COMMUNITY SERVICES DEPARTMENT

September 17, 2020

Subject: Bent Grass West PUD Preliminary Plan (PUDSP-205)

SITE PLAN NORTH

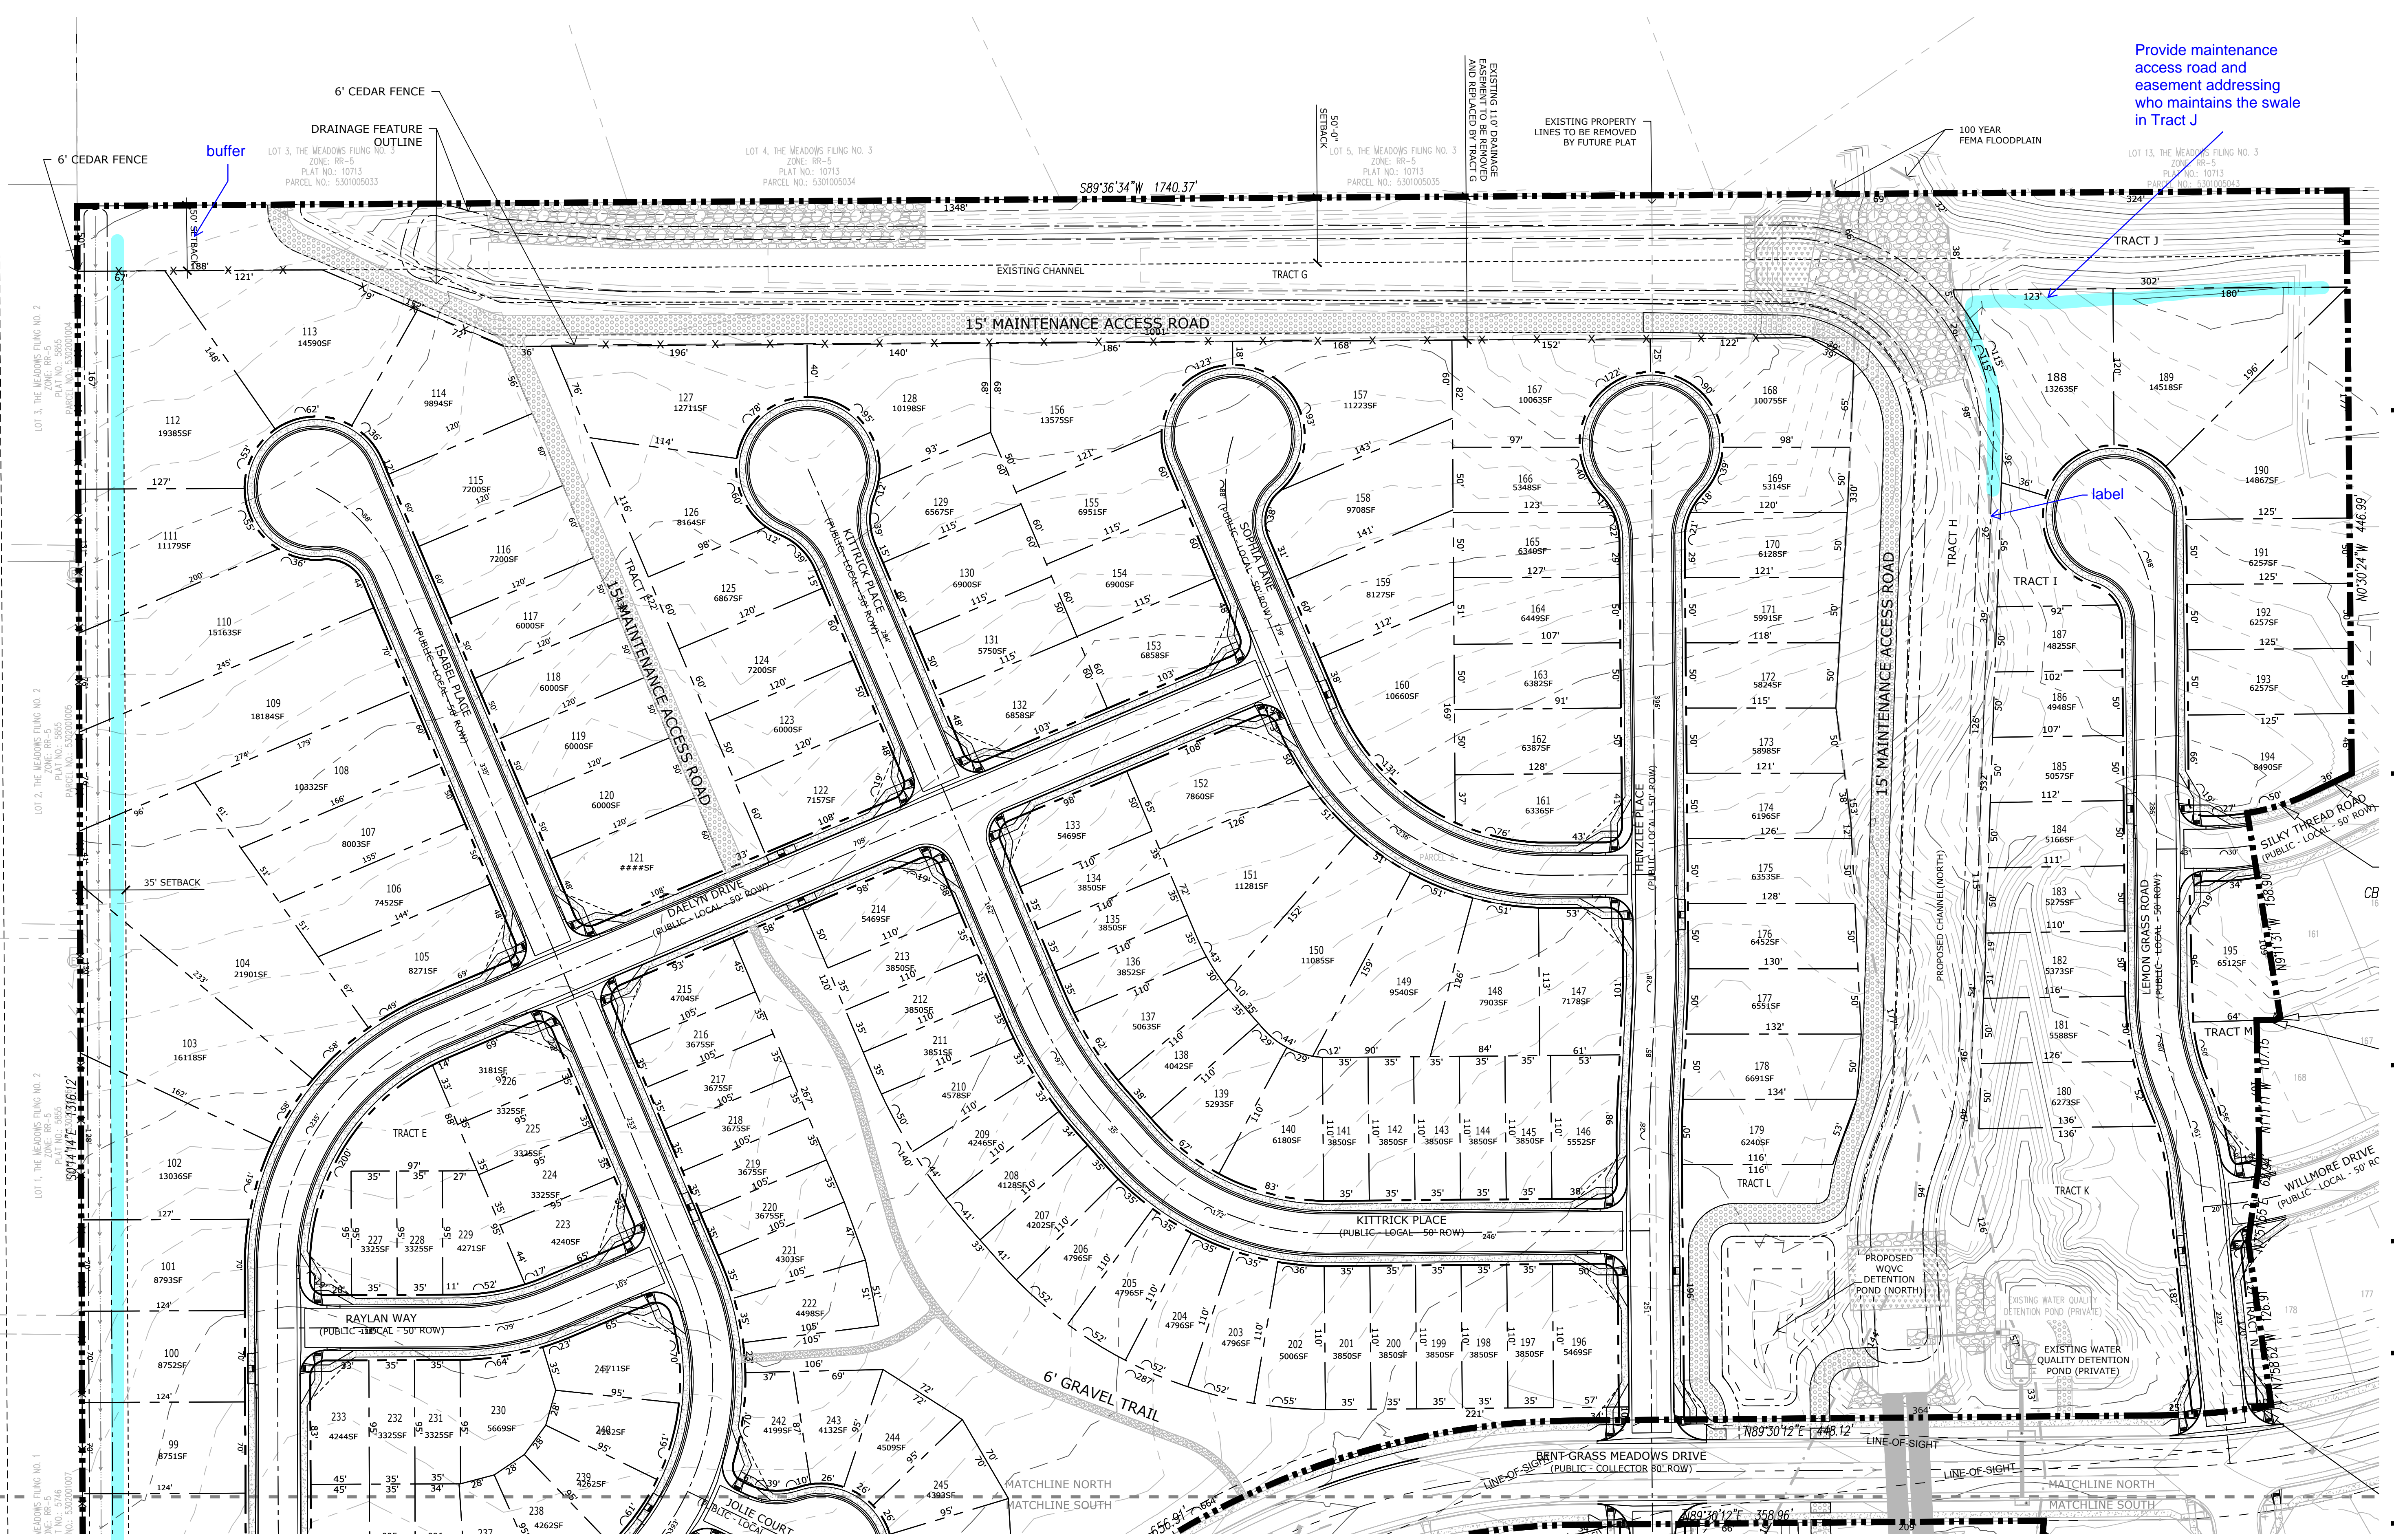
The 2013 El Paso County Parks Master Plan shows the proposed Woodmen Hills Secondary Regional Trail trending north-south through the middle of the Bent Grass West site. Consistent with the master plan, the applicant is showing a trail along the central drainage channel, however the 25-foot easement is only shown south of Bent Grass Meadows Drive. Please revise the PUD Preliminary Plan drawings to include the 25-foot trail easement north of bent Grass Meadows Drive along the central drainage channel. No other parks, trails, or open space are impacted by this development, and the project site is not located within any Candidate Open Space Area.

The Park Advisory Board recommends that the Planning Commission and the Board of County Commissioners include the following conditions when considering and / or approving the Bent Grass West PUD Preliminary Plan: (1): Designate and provide to El Paso County a 25-foot trail easement along the proposed drainage channel that allows for public access, as well as construction and maintenance by El Paso County of the Woodmen Hills Secondary Regional Trail. required fees in lieu of land dedication for regional park purposes in the amount of \$122,354 and urban park fees in the amount of \$77,290 will be required at time of the recording of the final plat(s). A park lands agreement may be an acceptable alternative to urban park fees provided the agreement is approved by the County and executed prior to recording the final plat.
